## Appeal Decision

**Appeal Ref: APP/R5510/D/23/3332140**

**51 York Road, Northwood, Hillingdon, HA6 1JJ**

Modhwadia Design Services	Project: 51 York Road Northwood HA6 1JJ	Title: As Built Elevations	Scale: 1:100 @ A3 Date: June 2022 Drawing No.: MD/6020 - 10/MT Revision
239 Western Road, Southall, Middlesex, UB2 5HS 020 8571 1369

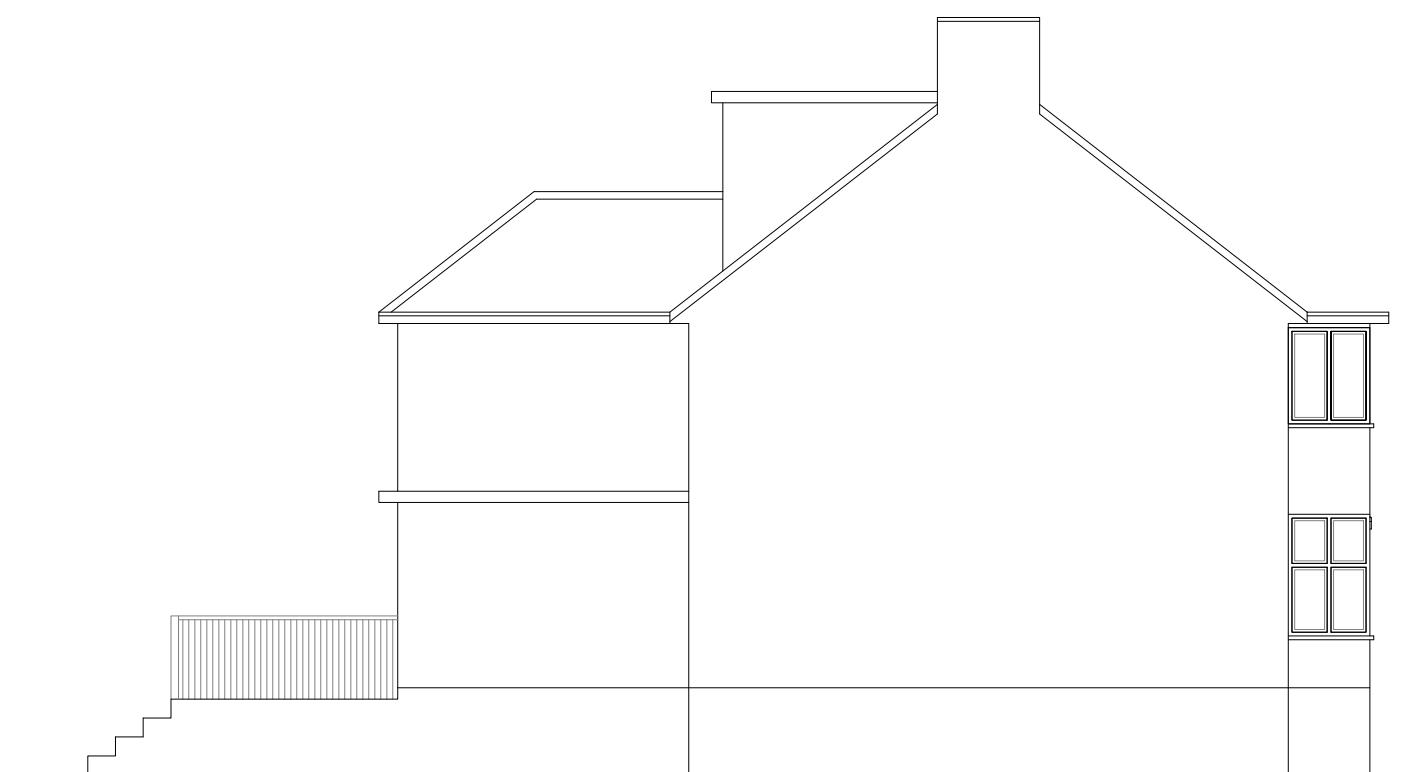
6. The Council notes that the constructed part single storey/part two storey rear extension has not been built in accordance with the revised drawings attached to this permission; and that the "as-built" plans relating to the application the subject of this appeal do not accurately reflect the height of the installed fencing along the shared boundary with Number 49 York Road.

13. The development includes a hip to gable conversion and a large rear dormer. The visual impact of this is emphasised as a result of a change in levels between the appeal property and its neighbour, Number 53 York Road, which sits at a considerably lower level. During my site visit, I observed that the appeal property's gable roof and large rear dormer appear visually dominant, to the extent that they tower above No 53 in close proximity to that dwelling.

14. The harm arising from the above is exacerbated as a result of the roof level development at No 51 appearing significantly different to the roofs of neighbouring dwellings. The large gabled roof with its front rooflights and large rear dormer draws attention to itself and contrasts with the appearance of the hipped roof of the adjoining dwelling, Number 49 York Road, as well as with the hipped roofs of other pairs of dwellings close to the appeal property. This results in the development unbalancing the symmetry between Nos 49 and 51 and jarring with the area's identified sense of uniformity.

15. Further to the above, together, the hip to gable extension and large rear dormer appear unduly bulky and visually awkward against the two storey element of the rear extension approved by the planning permission referred to above. This adds to the incongruous appearance of the development and results in an extension which overwhelms and fails to appear subordinate to the original appearance of the host property.

16. In addition to the above, the raised terrace to the rear of the appeal property appears as a large and prominent feature. Combined with the very tall boundary fencing adjacent to it, the raised terrace draws attention to itself as a form of development unlike any other in the surrounding area and as such, it appears as an incongruous, dominant and visually intrusive form of development.
17. Taking all of the above into account, I find that the development harms the character and appearance of the area, contrary to the National Planning Policy Framework; to London Plan (2021) Policies D3 and D4; to Local Plan<sup>2</sup> Policy BE1; and to Development Management<sup>3</sup> Policies DMHB11, DMHB12 and DMHD1, which together amongst other things, seek to protect local character.
